**WELWYN HATFIELD BOROUGH COUNCIL
EXECUTIVE DIRECTOR - PLANNING, PUBLIC PROTECTION AND GOVERNANCE**

Application No: 6/2018/3129/FULL
Location: 16 Horsa Gardens Hatfield AL10 9GF
Proposal: Erection of single storey rear extension and conversion of existing terraced single dwelling into 1 x 1B ground floor apartment and 1 x 2B two storey maisonette at first and second floor above
Officer: Ms Lucy Hale

Recommendation: Refused

drawing title: EX / PROP BLOCK PLANS

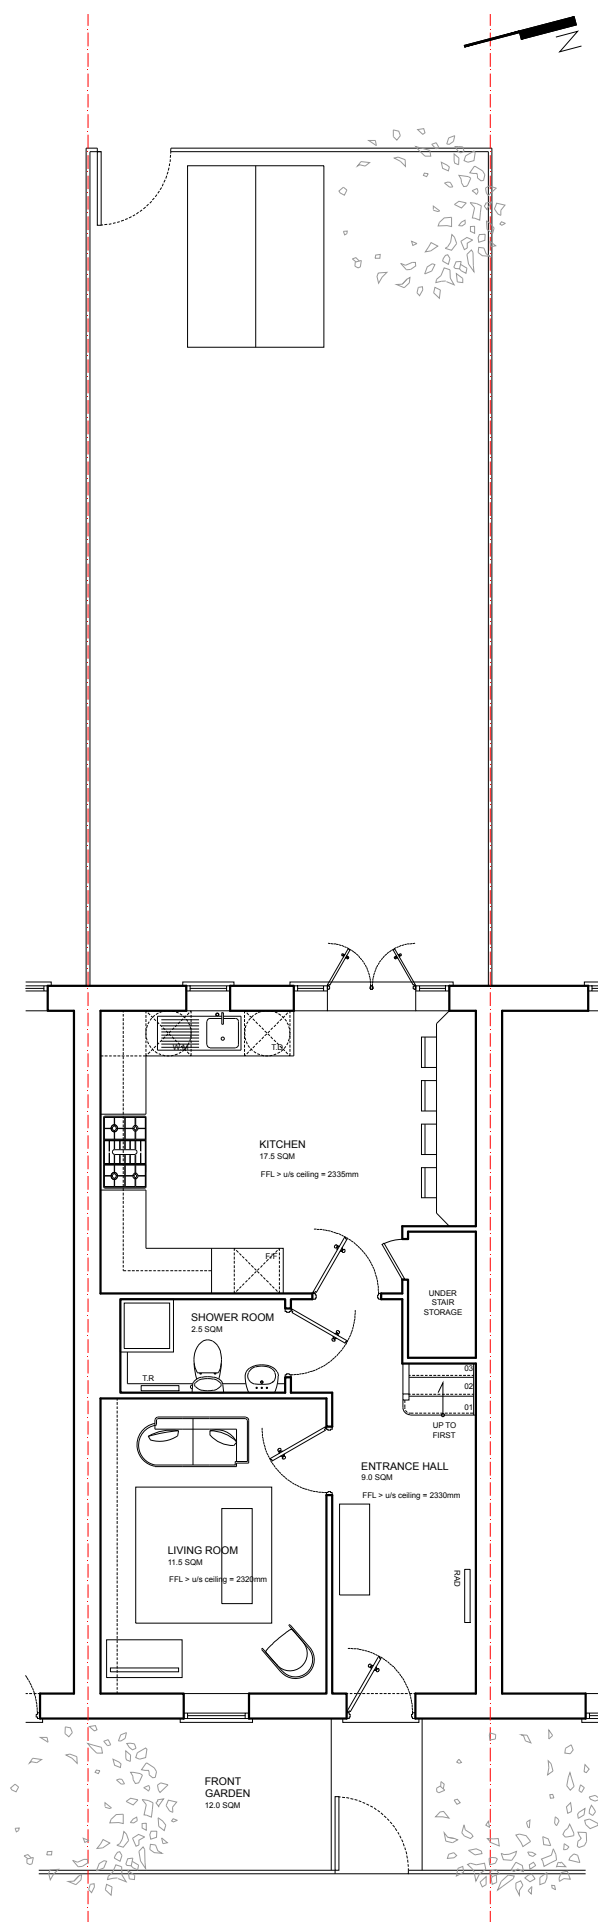
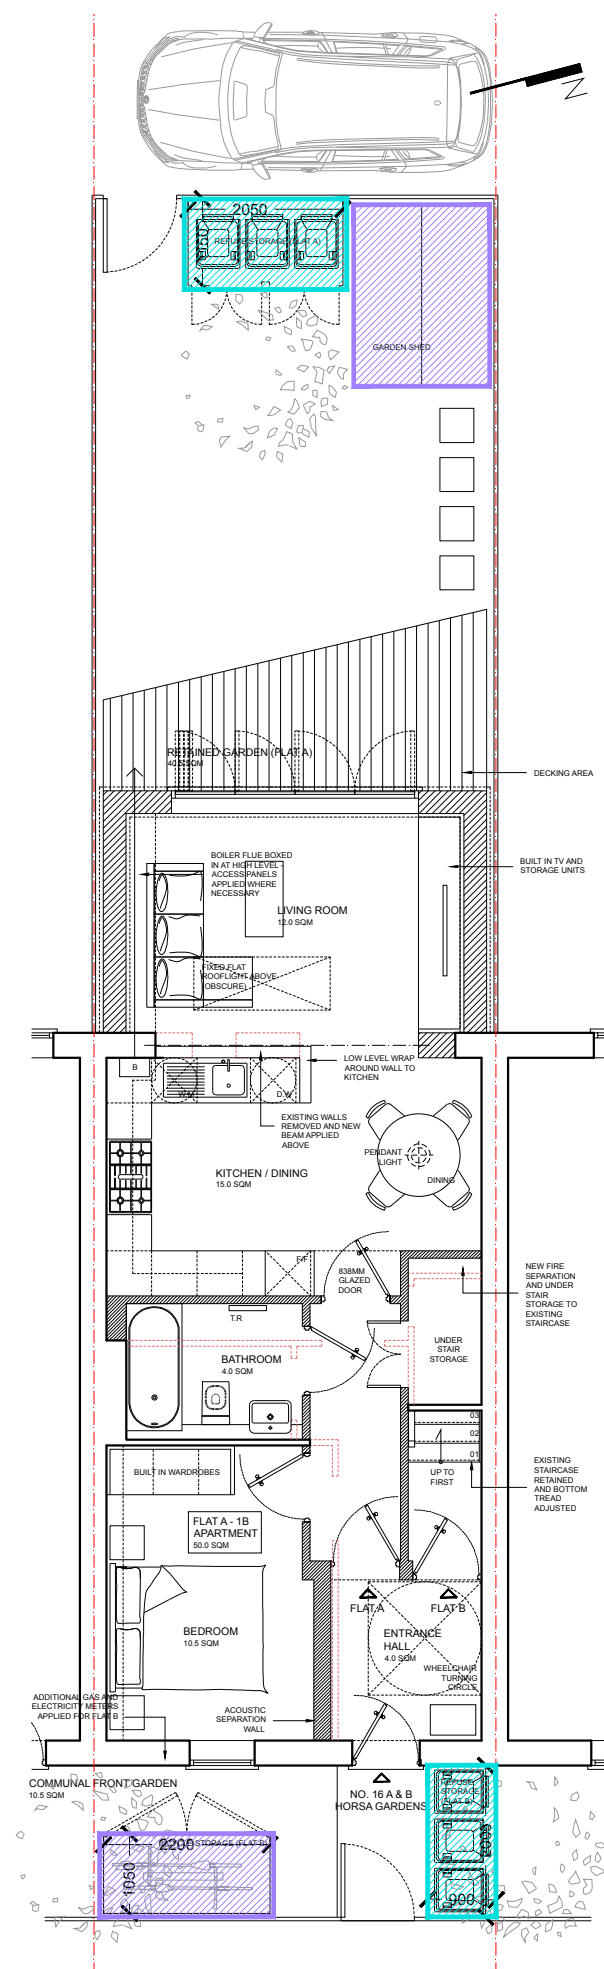
<p>Refuse and recycling</p>	<p>Details of bin storage have been provided and are proposed to be located to within the rear garden to serve Flat A and to the front of the site to serve Flat B. Client Services object to the location of the bin storage to the front of the site and would result in an unacceptable distance and movements given the bins are collected to the rear of the site. Furthermore, the proliferation of bins can create a considerable amount clutter which in turn has a harmful impact upon the visual amenity of the streetscene and the character of the area contrary to Local Policies D1 and D2. The existing dwelling benefits from a small fenced area to the front which comprises soft landscaping. The frontages along Horsa Gardens are consistent with some of these areas open with hard surface and others which feature soft landscaping. Whilst precise details have not been included in regard to the elevations and design, the introduction of bin storage and cycle storage within this location would result in clutter and would be harmful to the visual amenity of this immediate area and wider Landscape Character Area.</p>

3. The proposed development would fail to provide refuse and recycling storage for the first and second floor flat within acceptable carry distance of the highway. The location of the refuse storage would be inappropriately designed and fail to perform its role effectively. Furthermore, the location of the refuse storage would result in clutter and harm to the visual amenity and character of the area. This design would be contrary to Policy D1 and D2 of the Welwyn Hatfield District Plan 2005; Policies SP9 and SADM12 of the Welwyn Hatfield Borough Council Draft Local Plan Proposed Submission August 2016; and requirements of the National Planning Policy Framework 2018.

drawing title: EX / PROP BLOCK PLANS - PARKING

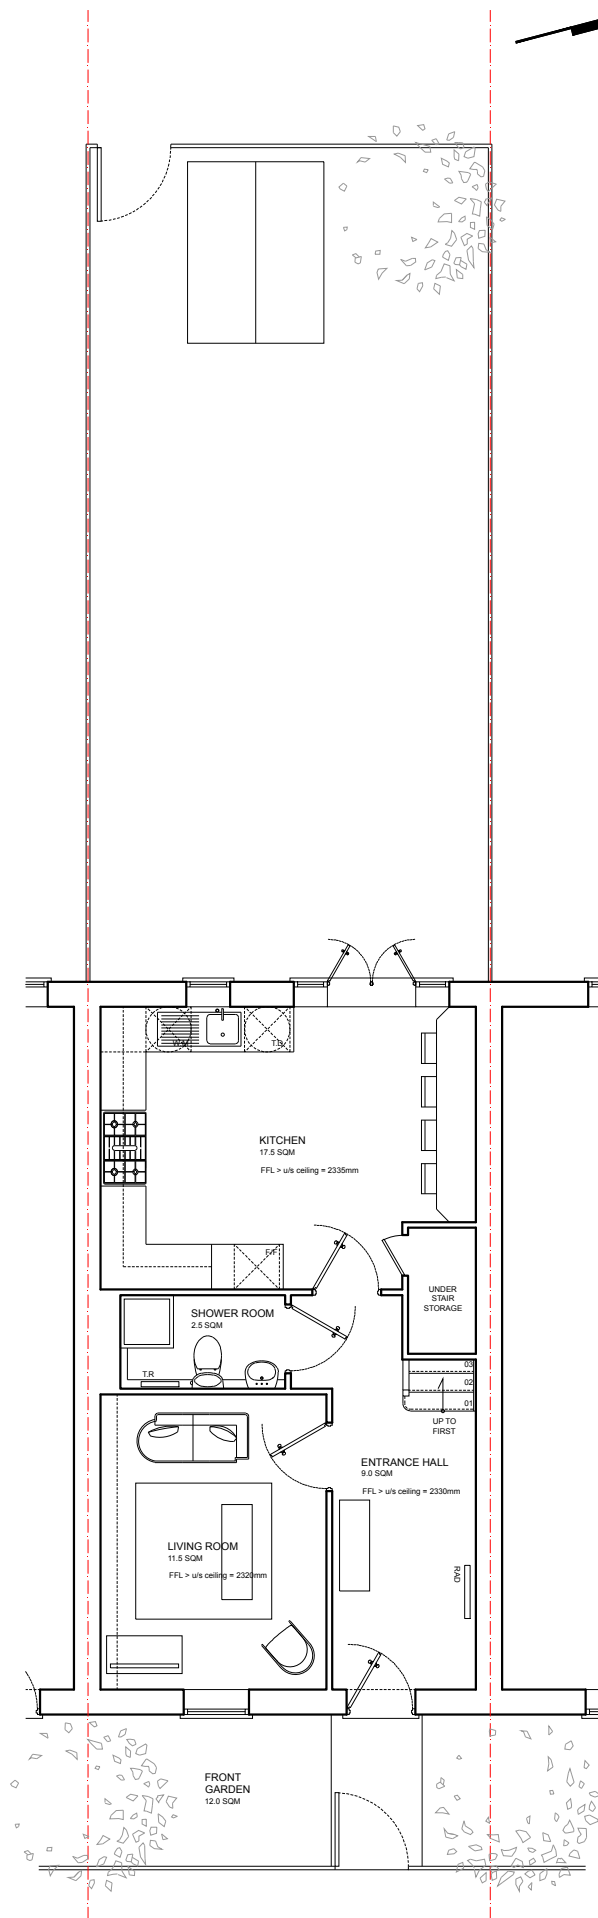
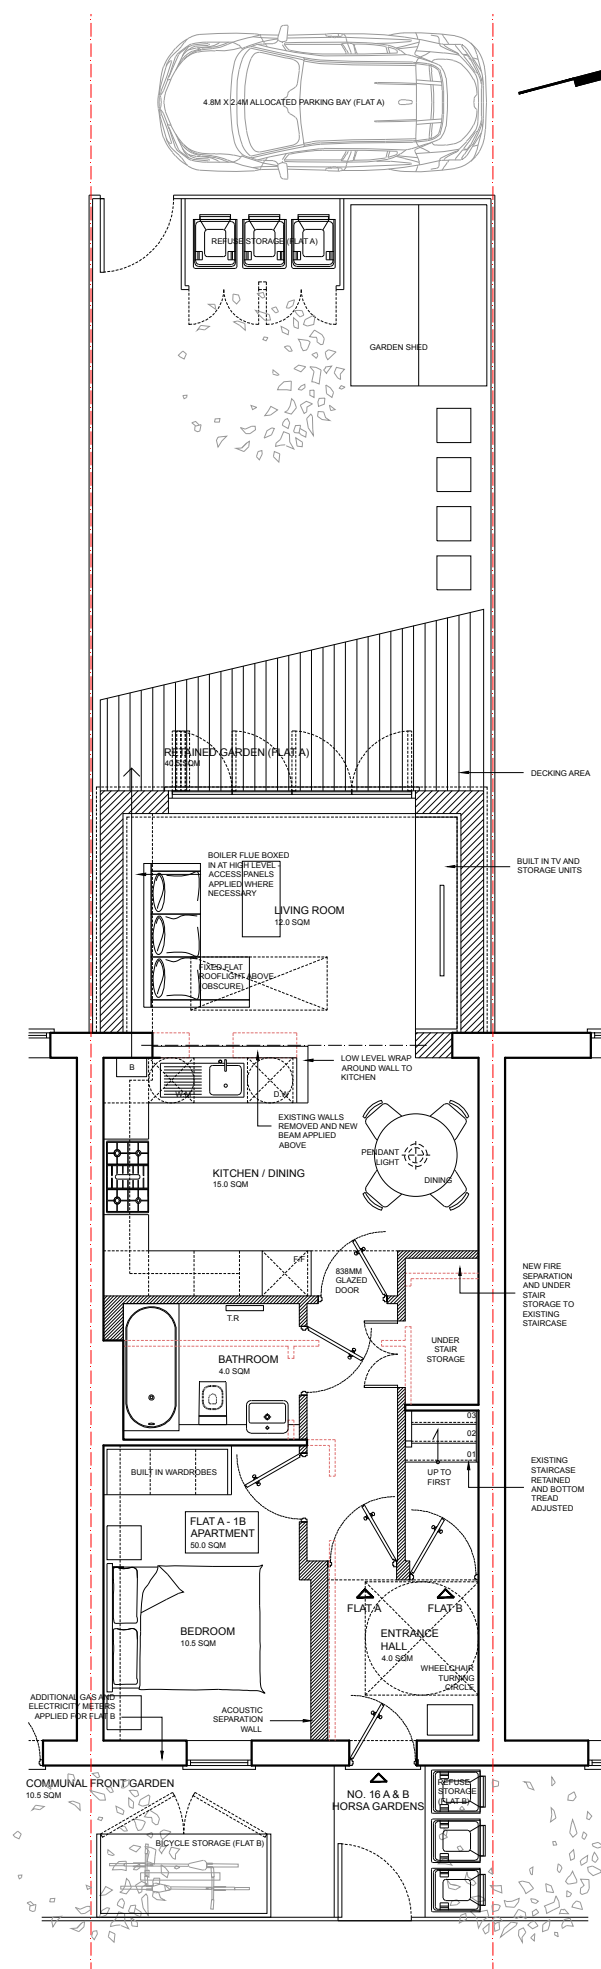
During the application, the applicant has submitted a further drawing to indicate a proposed car parking space immediately behind the rear boundary of the site within the communal courtyard. Whilst the applicant has outlined that cars do park behind the boundary fences within this courtyard, which was evident following a site visit, this is an informal set up and it is evident that the pressures in the number of cars already present within this courtyard. The space immediately behind these dwellings provides rear garden access and turning space for the allocated spaces directly in front of the garages. Allowing a permanent space in this location would not be an adequate or practical solution and would exacerbate the parking pressures within this area. Furthermore, if planning permission were to be granted it would be difficult to resist similar applications from neighbouring properties. Although each proposal must be considered on its own merits, repetition of this type of development would result in a cumulative impact which would be likely to further increase the stress on parking provision within the locality resulting in a harmful effect on the character of the area.

The applicant has outlined there is an option for additional street permits. Parking Services have confirmed that the residents would be entitled to purchase three parking permits in a private parking area, however, this scheme does not guarantee an available space. Furthermore, it has been confirmed that the roads surrounding the development will become adopted

<p>highway. This means that the permit scheme currently operating on the surrounding highway will no longer be in place. Therefore, the option of using street permits to facilitate the parking requirement, is not considered to be an adequate substitute and does not overcome the concerns raised above in regard to an increased number of vehicles parked on the street.</p> <p>In conclusion, taking into account the proposed additional space to the rear of the site would not present an adequate car parking space, based on the current car parking allocation for the site, the proposal fails to propose a practical and satisfactory car parking provision for the future occupants of the site and the proposed development. In addition, the layout of the surrounding residential development would become cluttered and its overall appearance would be materially harmed by an increase in the presence of vehicles parked on-street. This adverse harm would be contrary to the saved Policies D1 and D2 concerning high quality design and character and context. These policies are consistent with the NPPF.</p>

1. The proposed car parking provision is not considered to adequately serve the proposed development. As a result of the existing parking pressures of on-street parking within the locality; the additional pressure to increase the number of vehicles on street would have a harmful effect on the character of the surrounding area. Accordingly, the proposed development would conflict with Policy M14 of the Welwyn Hatfield District Plan 2005; Supplementary Planning Guidance – Parking Standards 2004; Interim Policy for Car Parking Standards and Garage Sizes 2014 (Statement of Council Policy 2005); Policies SP9 and SADM12 of the Emerging Local Plan; and the National Planning Policy Framework 2018.
